YIEWSLEY PROPOSED PAVING MATERIALS

Also see plan mark-up sheets 1 & 2, 22.12.20

Drawing Title
Proposed Surface Materials

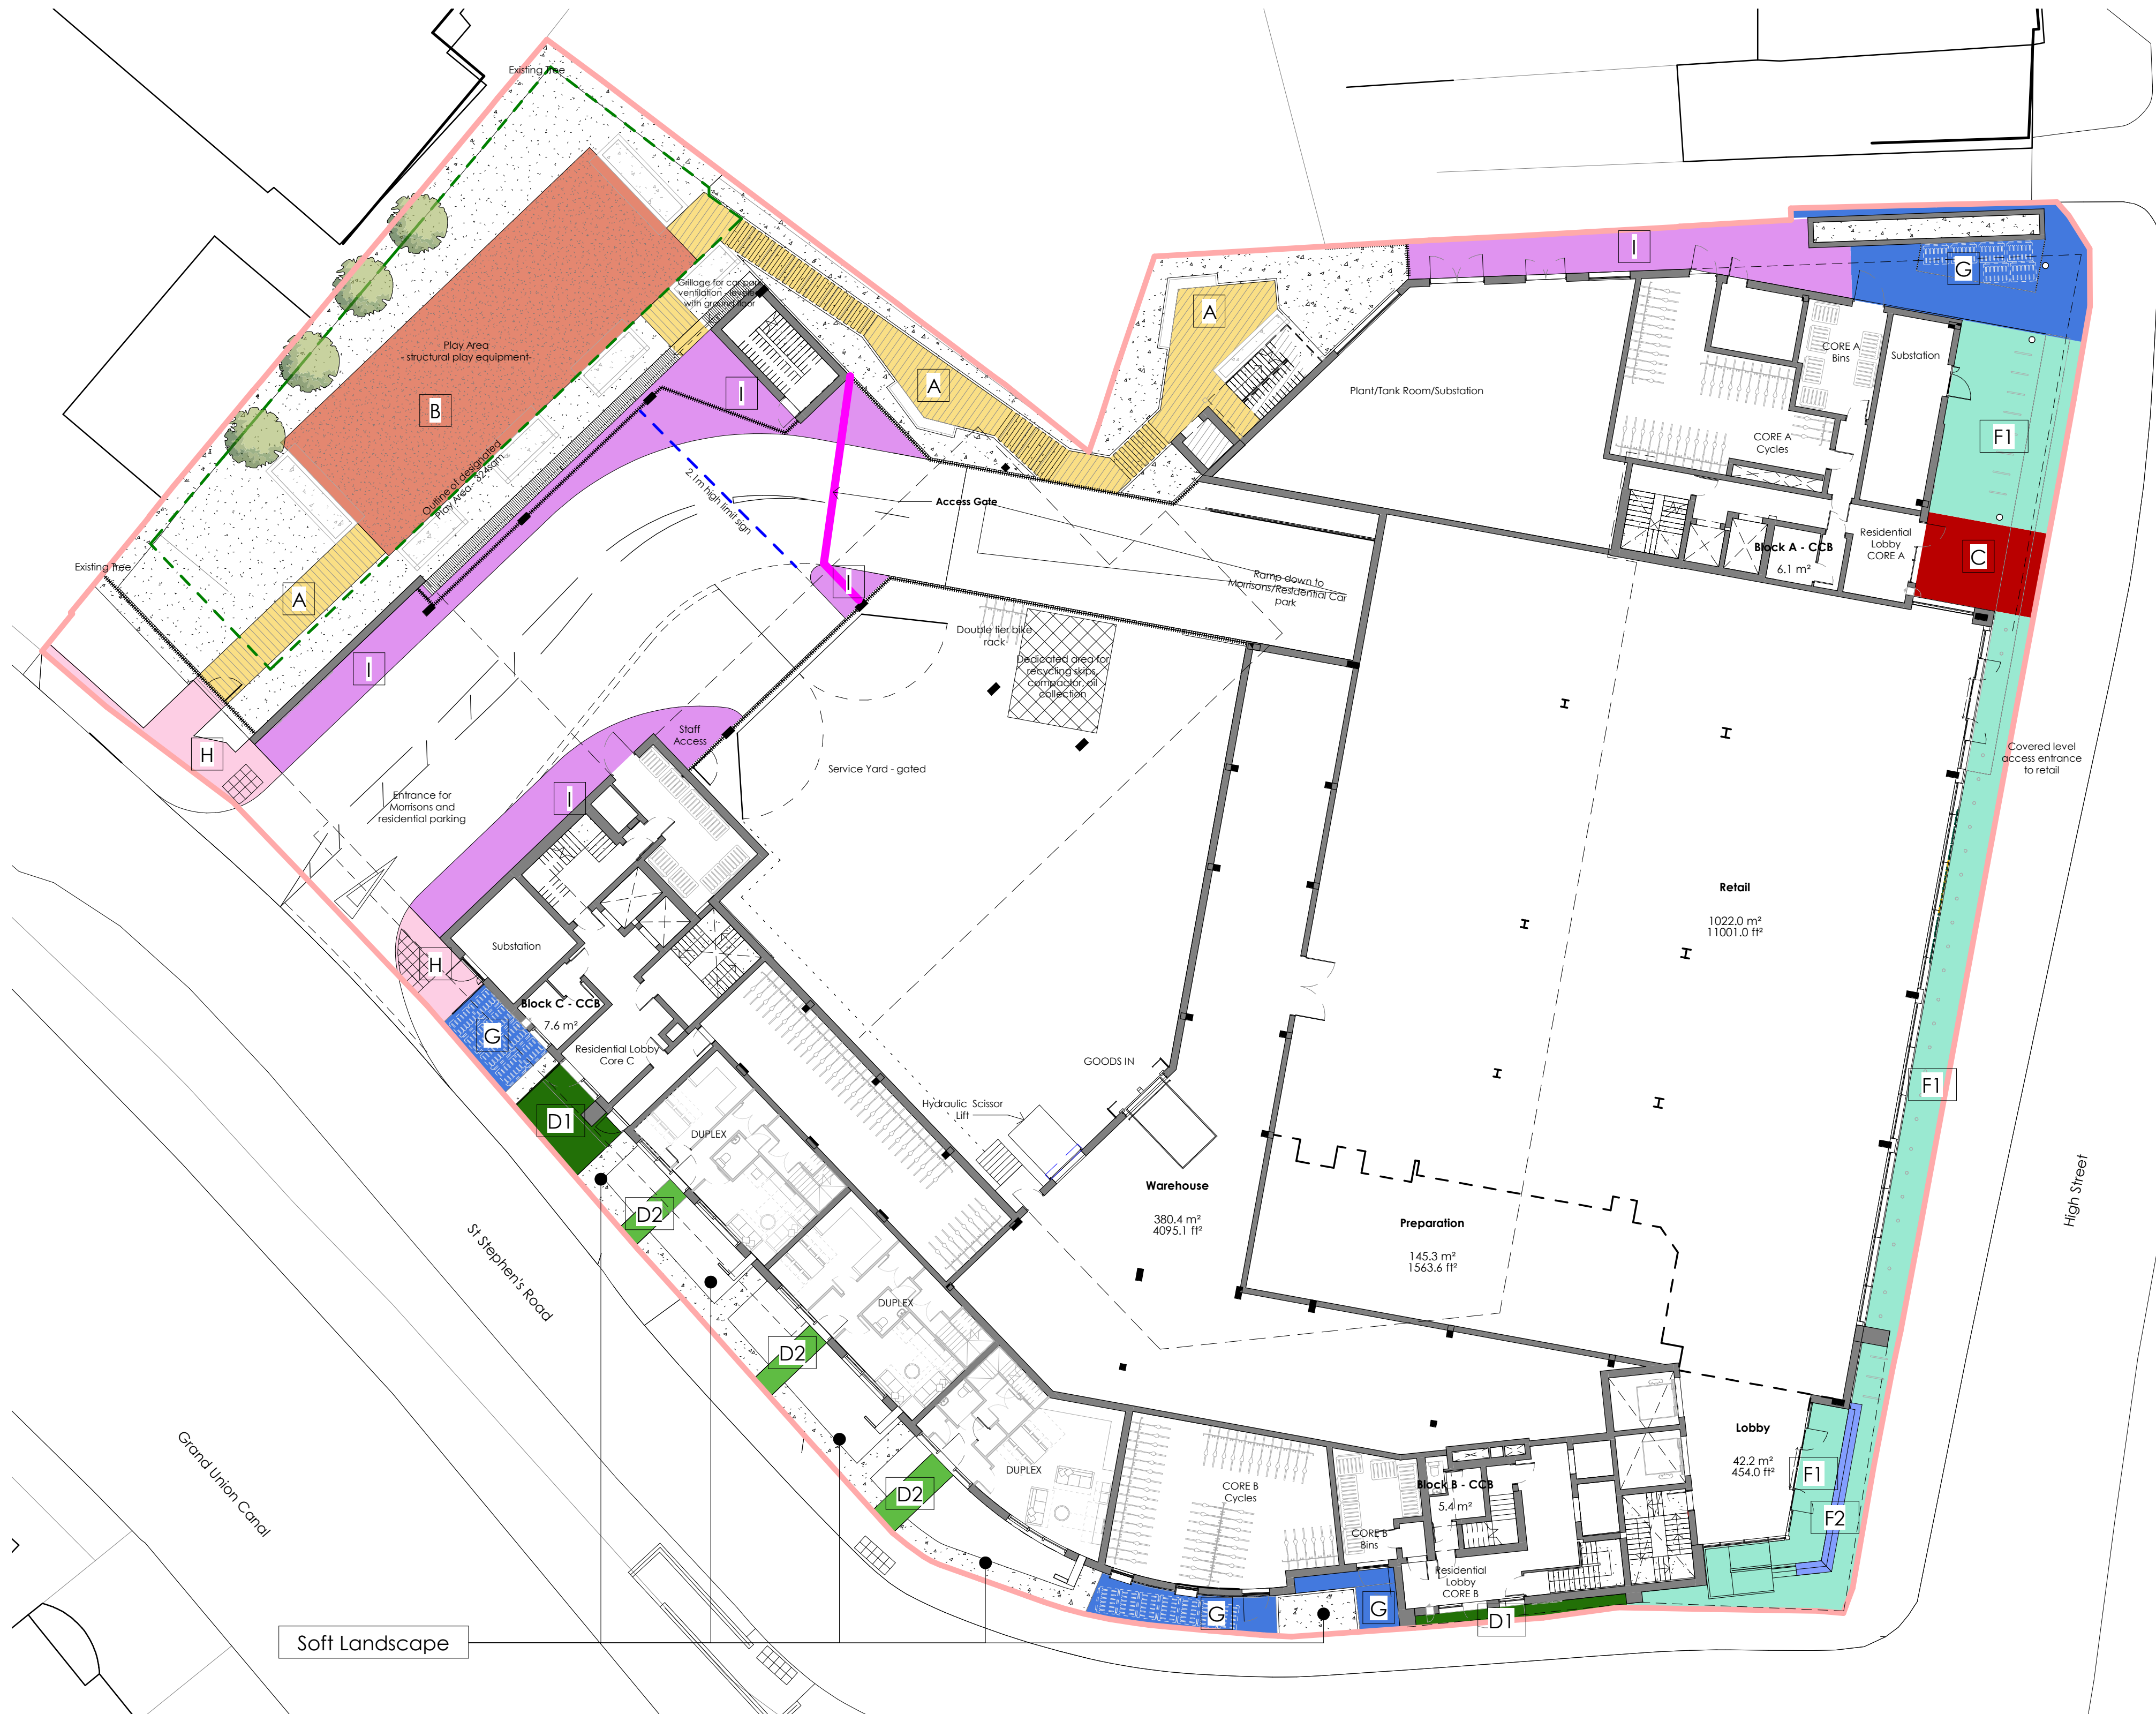
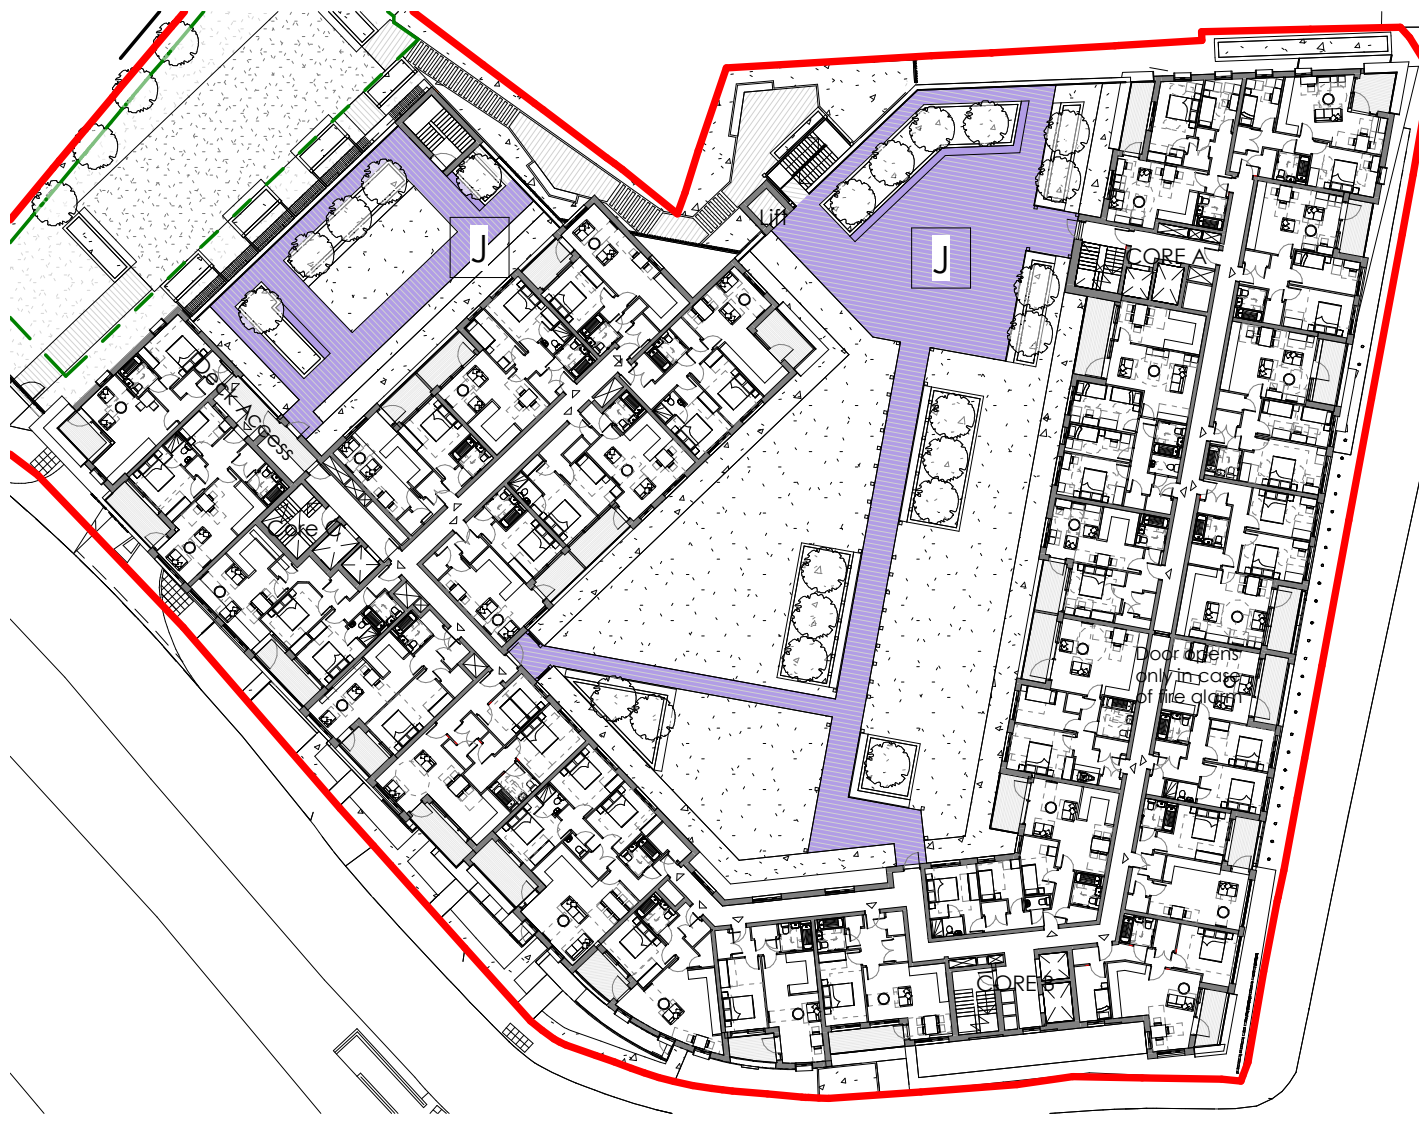
Note. The drawing suggests a different paving type and not RBG. If using RBG is a problem, change paving to Marshalls Conservation X Block granite aggregate sett paving in silver grey, with 'solid' paving areas for A1 to A6, and banded paving in gravel for A7 to A9.

Note: if this area is entirely bark mulch, there is no firm path connecting to the back of the flats. Is this an issue?

Note - should this category also include areas D1 and D5?

Note. Areas H1 and H 4 are outside the planning red line but will undoubtedly need to be reinstated at the completion of the works.
